CITY OF PORTLAND, MAINE
PLANNING BOARD

re: Conditional Use Appeal, Site Plan, and Chapter 500 Storm Water Permit approval for University of New England

On (Date) November 14, 2000 the Portland Planning Board voted 4-0 (Caron, Hagge, Rodriguez absent) on the following motions regarding the University of New England lecture hall addition and parking expansion:

ELIMINATE (12) PARALLEL PARKING EXISTING SPACES IN AREA AT REAR OF TOWN

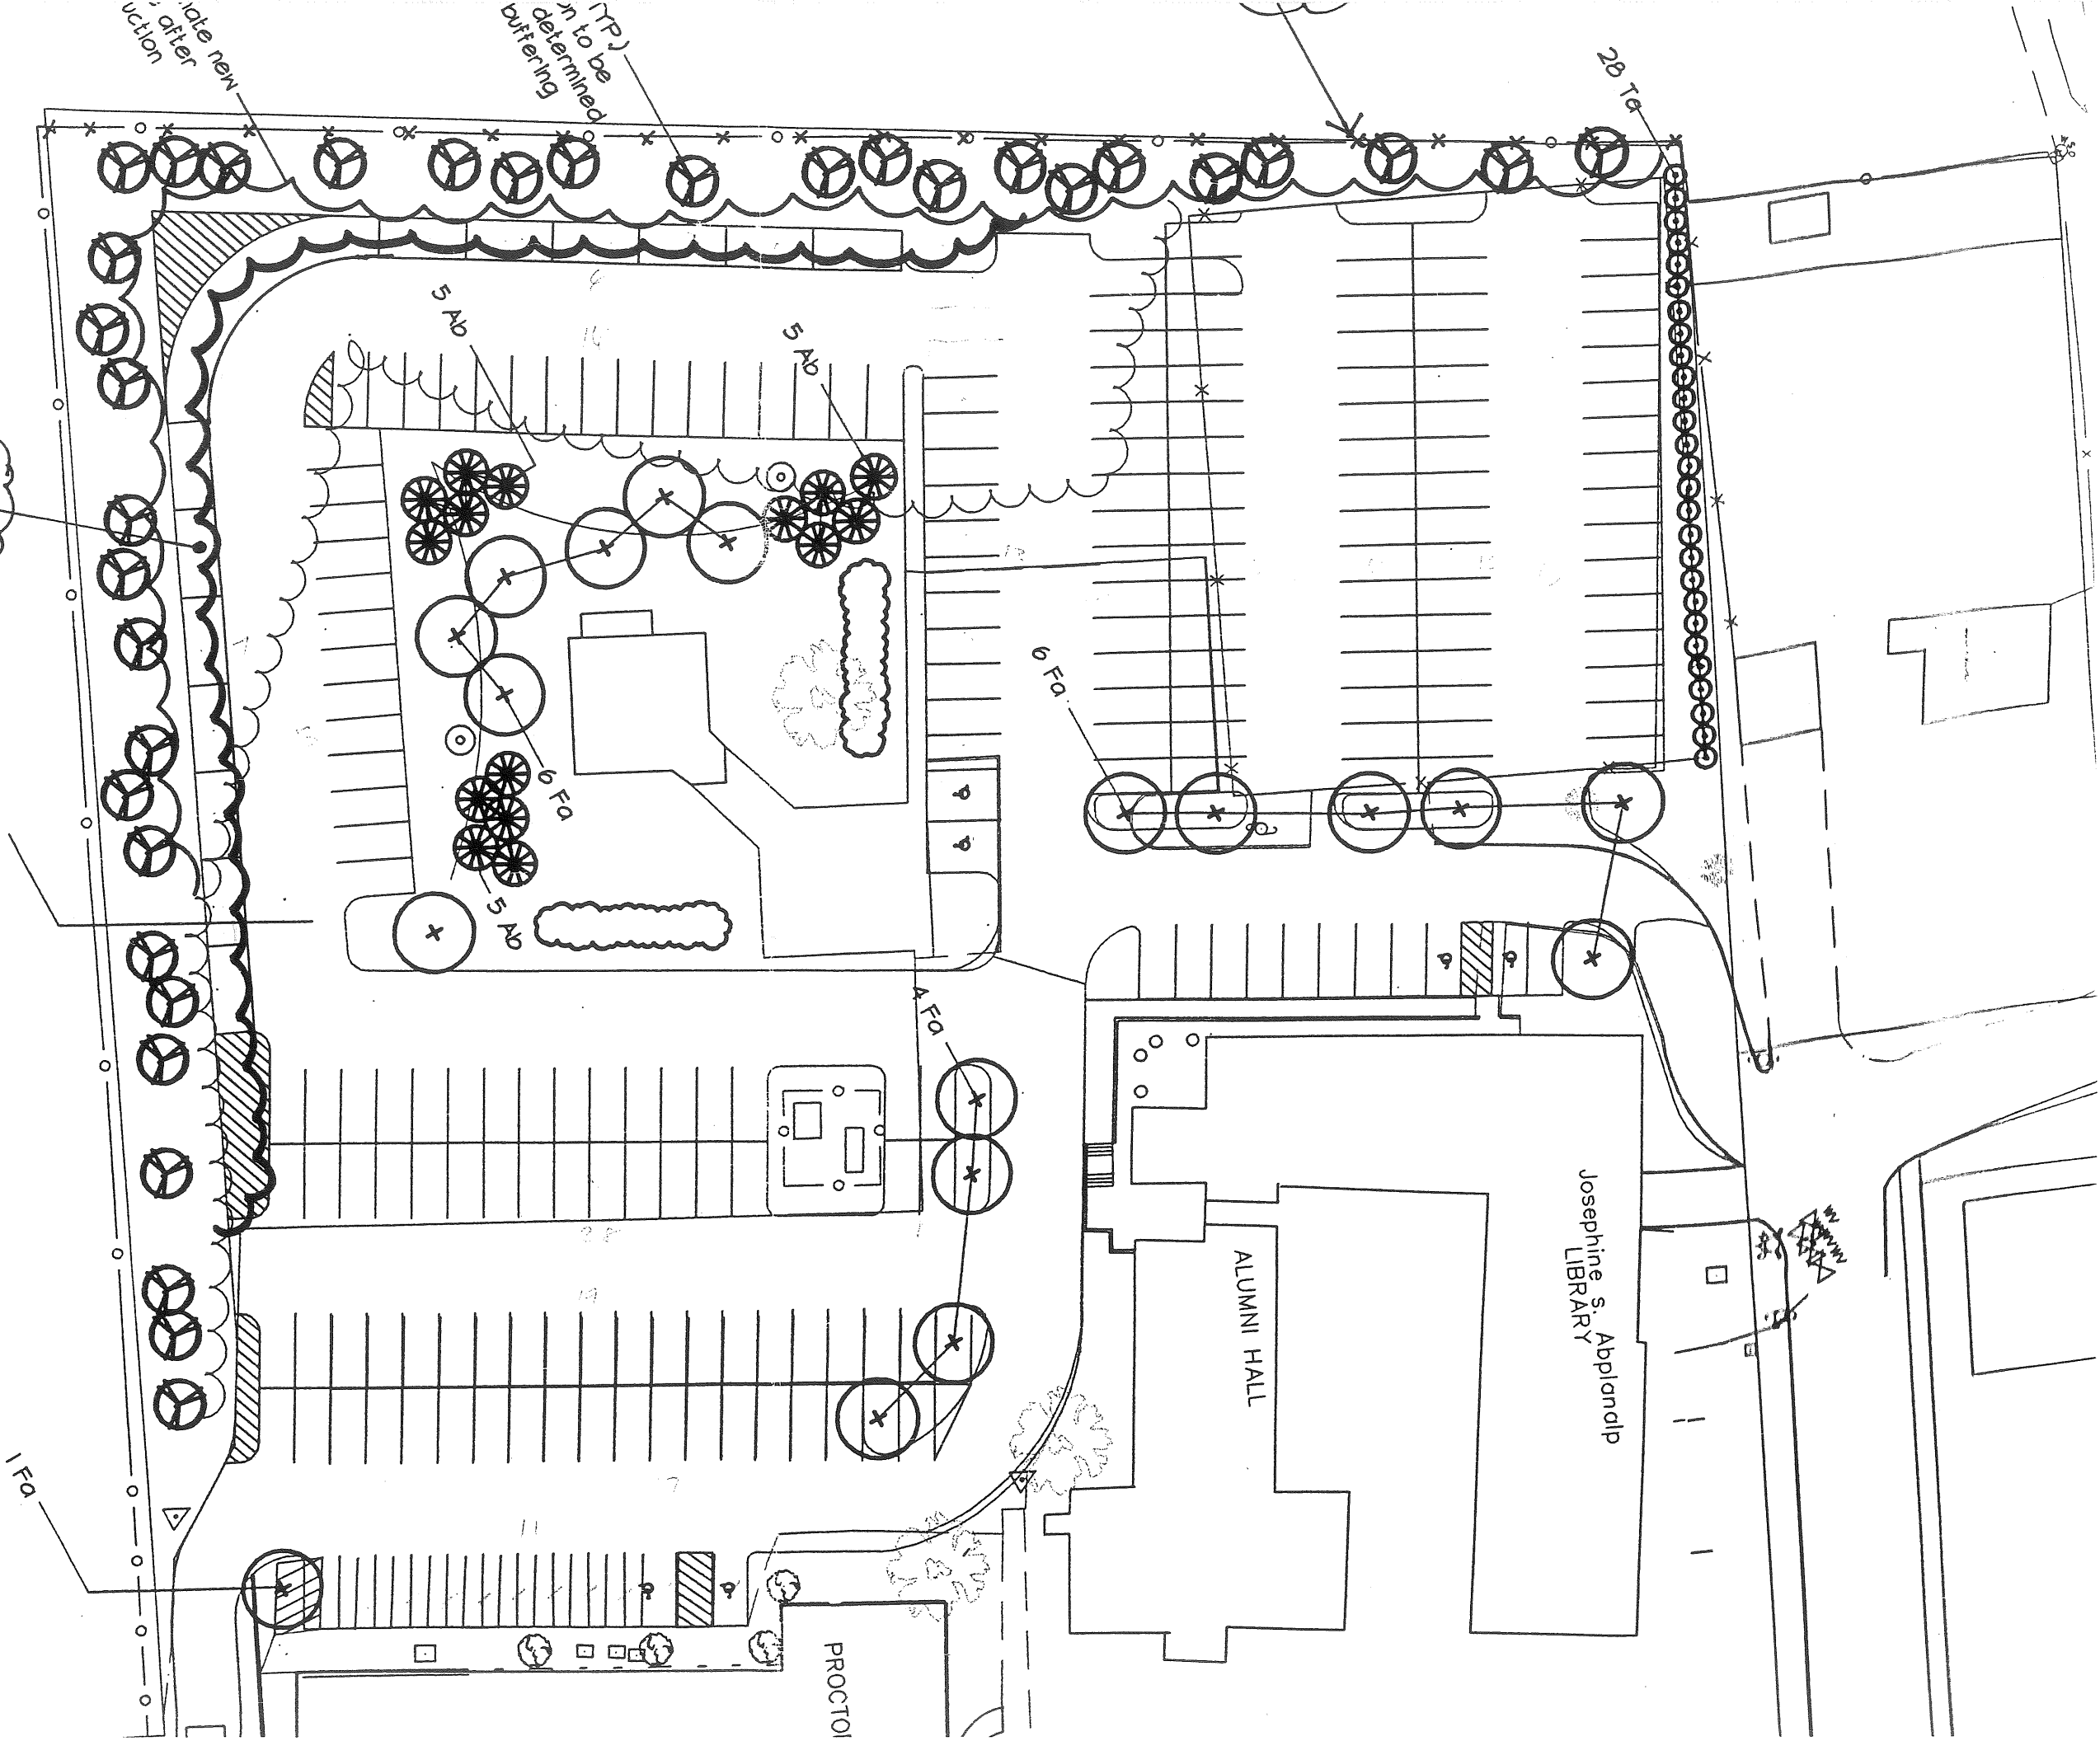
- v. That the 13 parallel parking spaces that abut the Evergreen Cemetery be omitted in order to provide a larger forested buffer and that the area remain in its natural state thereafter.
3. That the plan is in conformance with the standards for a Chapter 500 Storm Water Permit.

COURTYARD
LANDSCAPE &
LIGHTING PLAN
S-L1

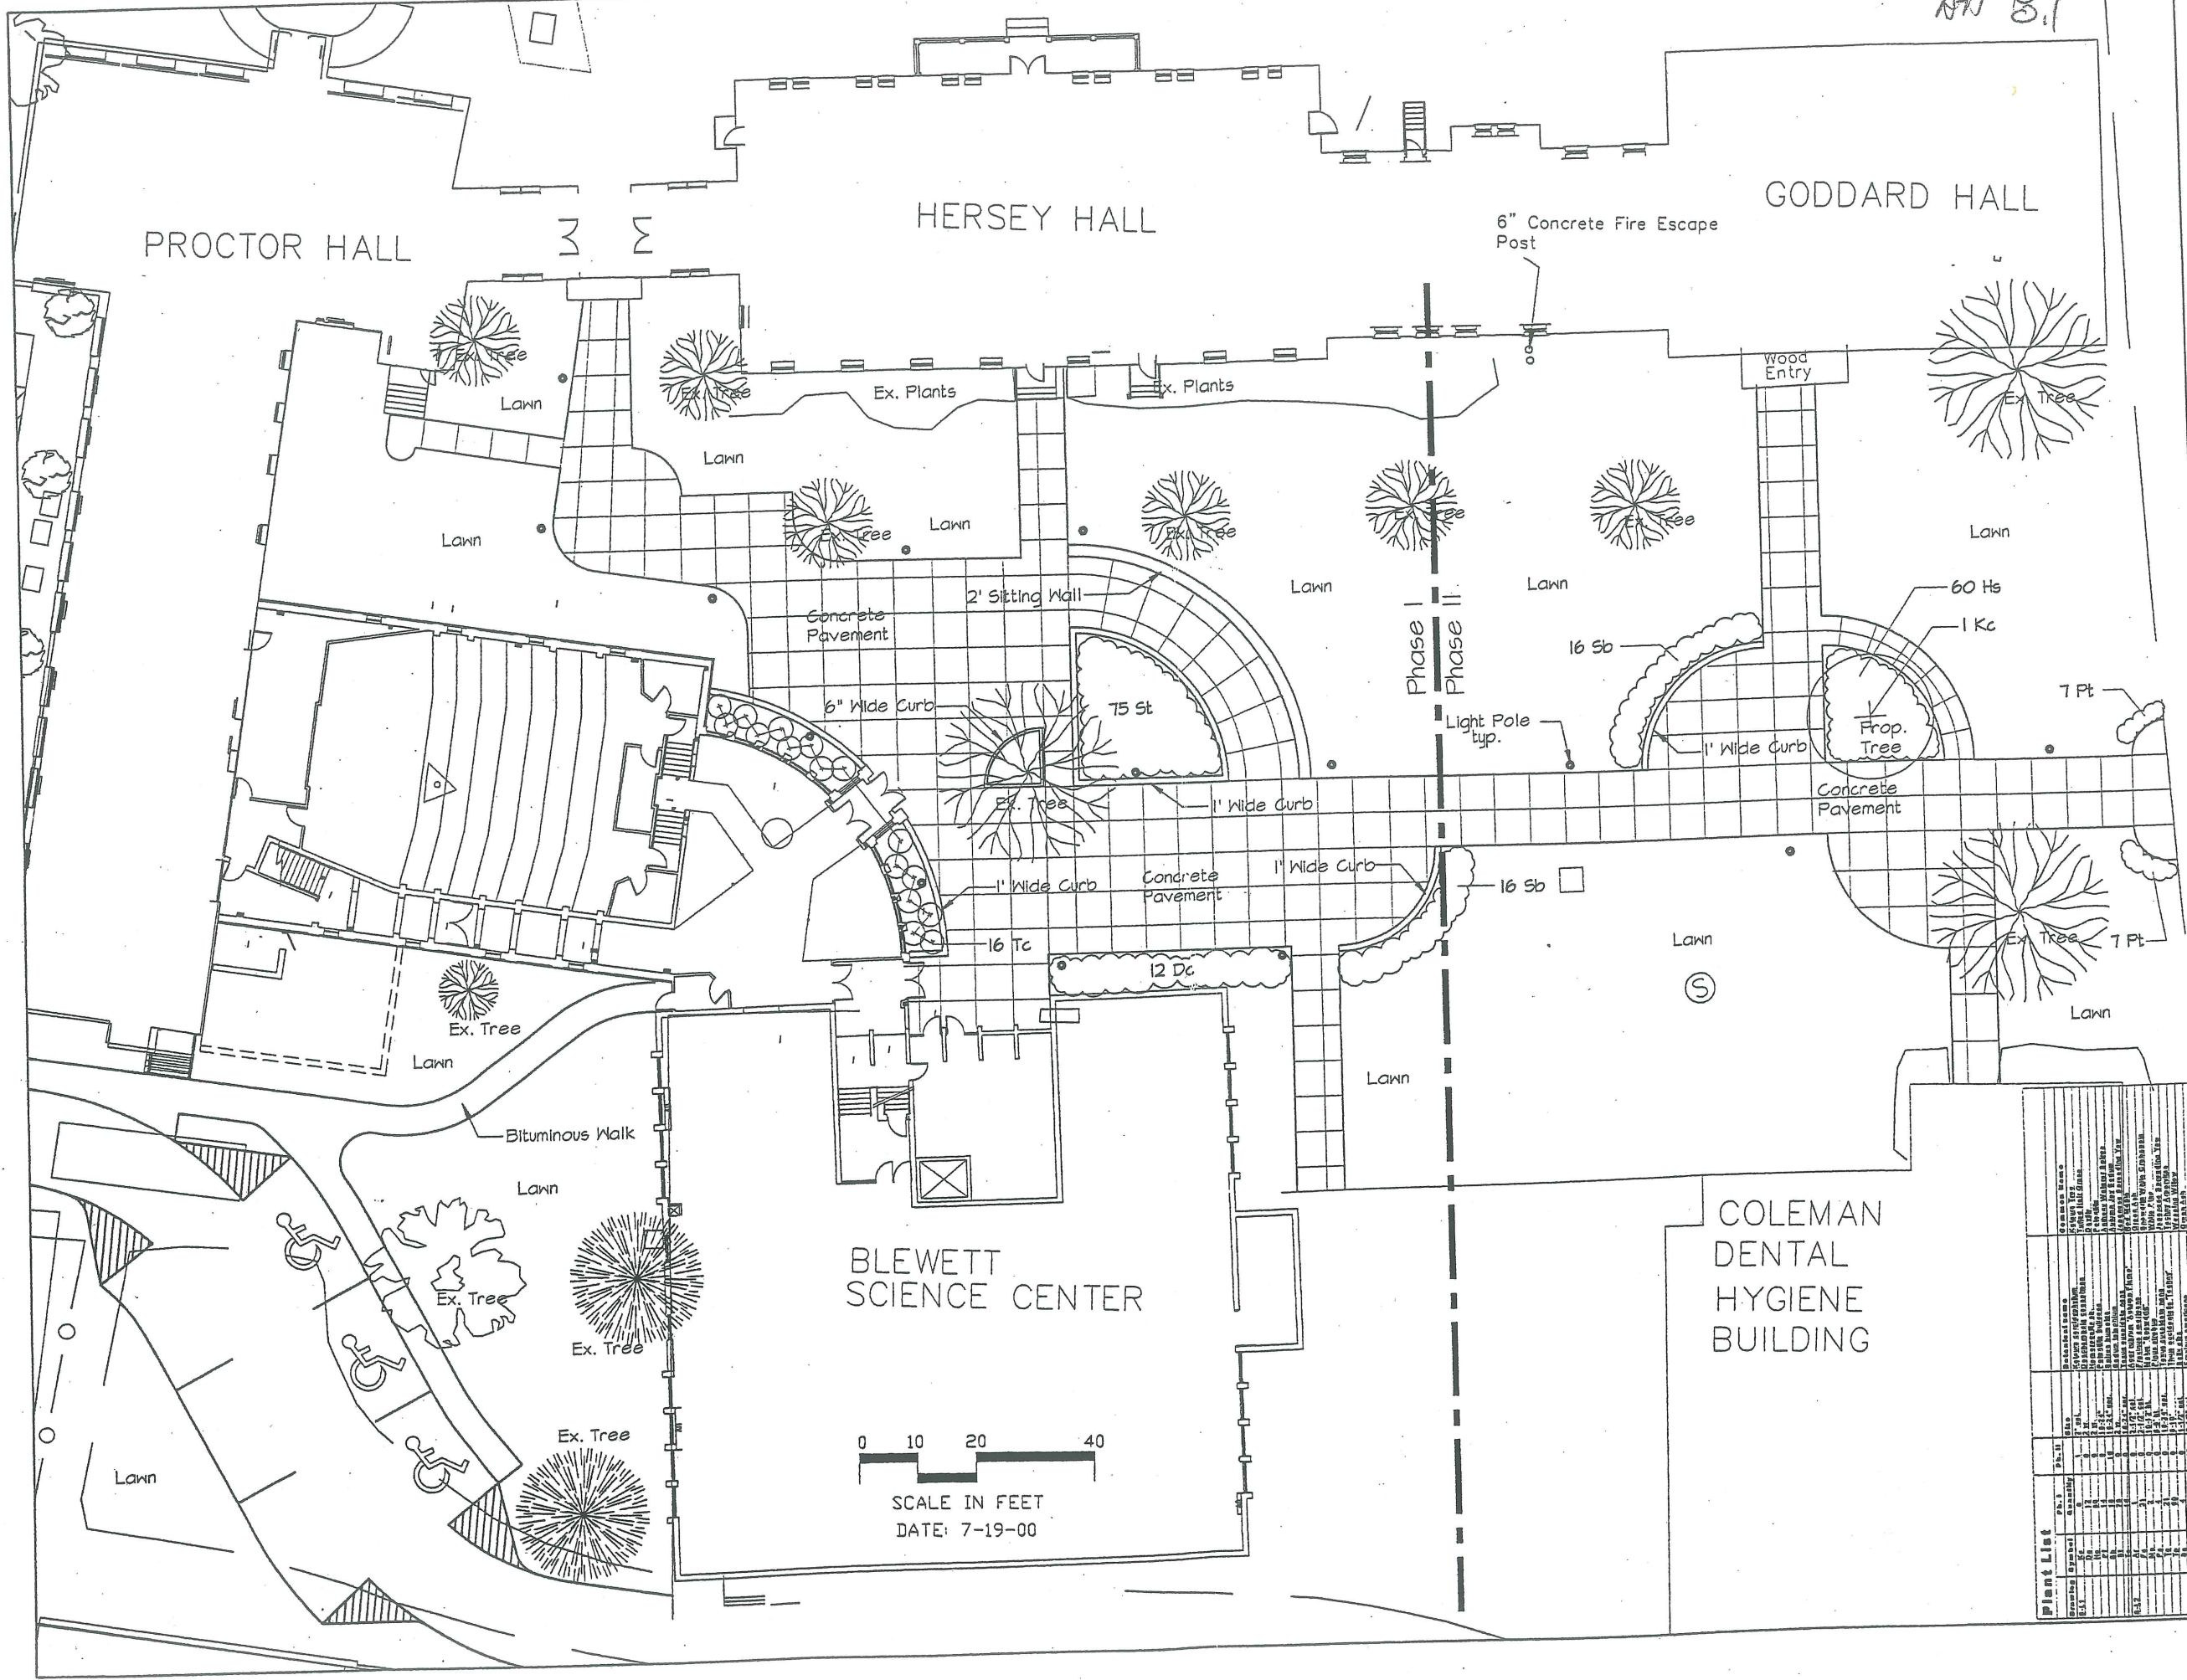
- ii. That the applicant supply a final traffic report for the City Traffic Engineer's review and approval.
 - iii. That the lighting plan be modified to show light fixture with wattage readings of no more than 250 Watts.
